Application Number: 2013-058      Application Date: 02/27/2013  
CBL: 431 M006001      Application Type: Level III Site Plan 50,000 - 100,000  
Project Name: Veranda St. Subdivision  
Address: 120 Veranda Street  
Project Description: Subdivision of 2 lots into 3 lots.  
Zoning: R5

**MEMORANDUM**

**Subject:** Application ID: 2013-058

**Date:** 4/3/2013

**Plan Depicting A Proposed Subdivision**  
Made For  
**Steven E. Cope & Roberta S. Cope**  
Northeastern Sideline Of Hodgkins Street  
& Northwestern Sideline Of Veranda Street  
Portland, Maine

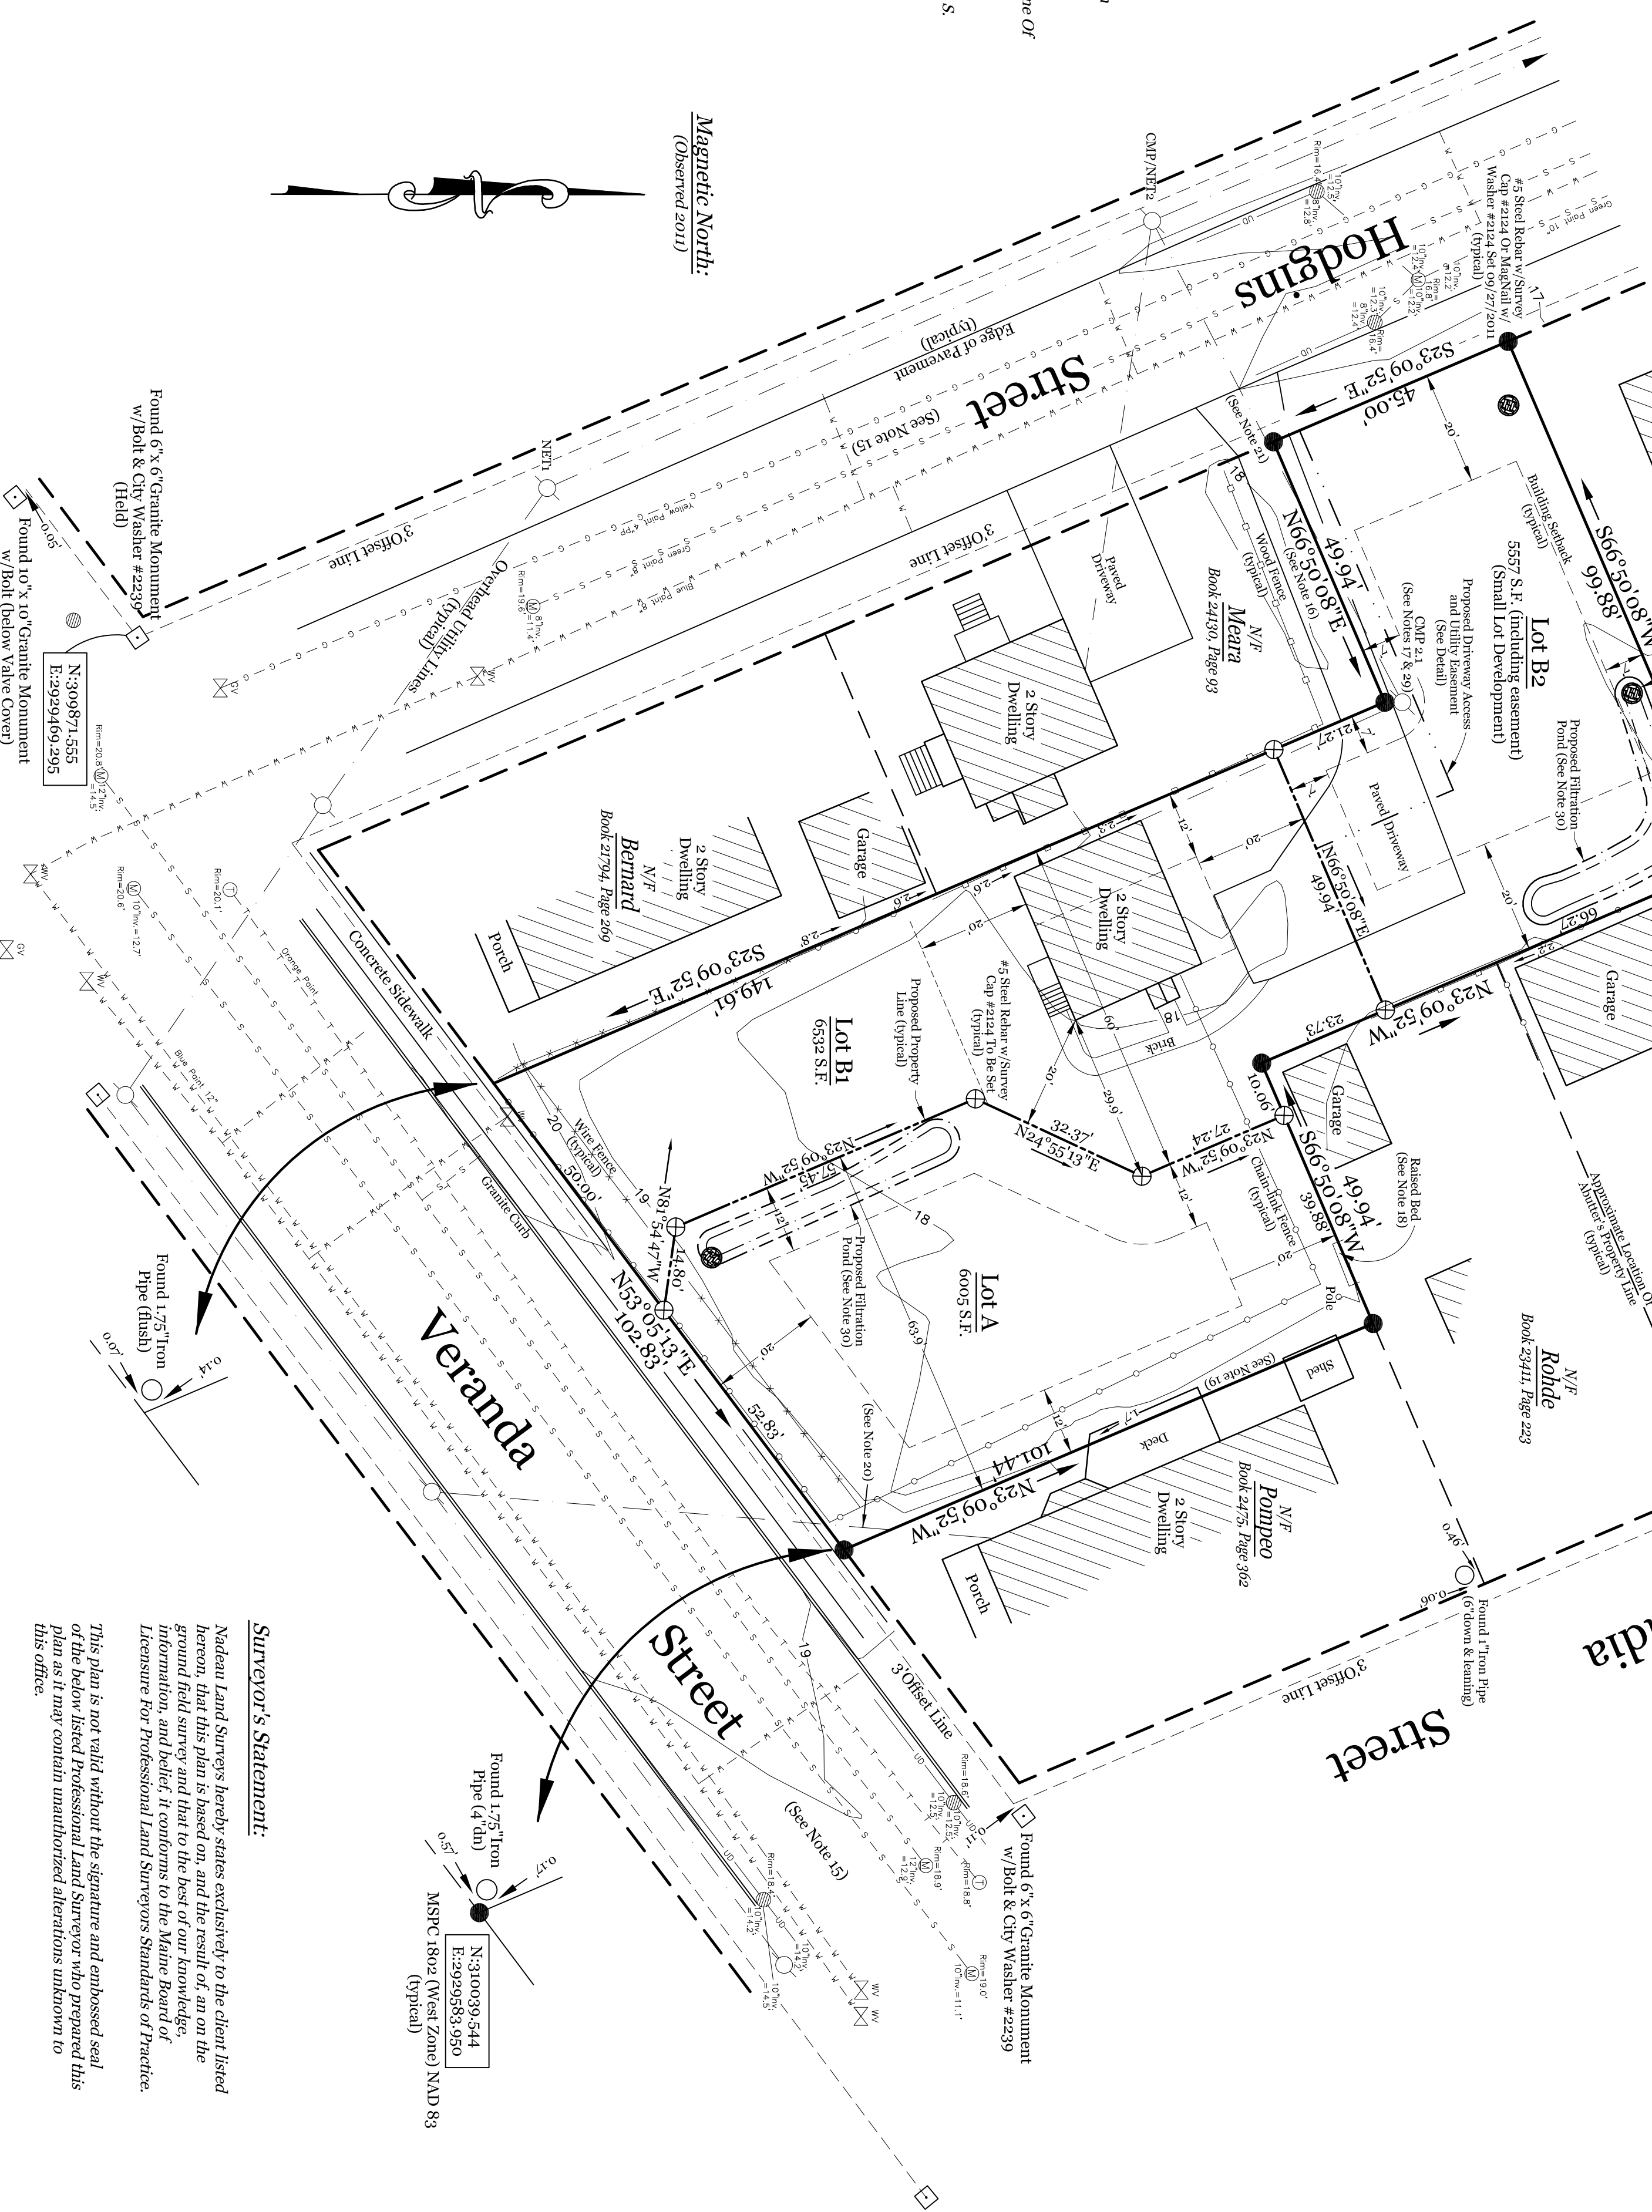
- ok \*
1. *This subdivision did receive a determination letter from me. The request for a subdivision review is for 3 lots which is correct. However, I believe that 4 potential dwellings should be part of the subdivision review. Lot "A", one of the new lots created using the regular R-5 zone requirements, can be developed as a two family by right. It would be correct at this time to include lot "A" as a two unit development. If that is not done now and the new owner of the property wants to put in a two unit and the PB only approved it as a one unit, the new owner would need to return to the Board. Better to include it now instead of bringing it back in 18 months.*

- \*
2. *Please note that lot B1 is an existing single family dwelling. It is fairly small, and I cannot see the availability to put on an addition for a 2nd dwelling unit. It is reasonable for this lot to only be reviewed as a single family dwelling.*

- \*
4. *On Lot "A" where the generic building is placed, violates the regular R-5 minimum lot width requirement. The regular R-5 zone requirements state there shall be a minimum of 60 foot for a lot width where a building is placed on a lot. The sketch should be revised to show that all regular R-5 zone requirements can be met. This will help eliminate any misunderstandings from a future purchaser of the land who will want to build on the lot and assume a building can be placed where it cannot.*

Response: We have revised the notes on the Subdivision Plat to indicate that Lot A can be developed as a two-unit development.

Response: We agree and have placed a note on the Plat that it can only be developed as a single family lot.

Response: We have revised the generic building footprint to show it meets all regular R-5 Zone requirements.
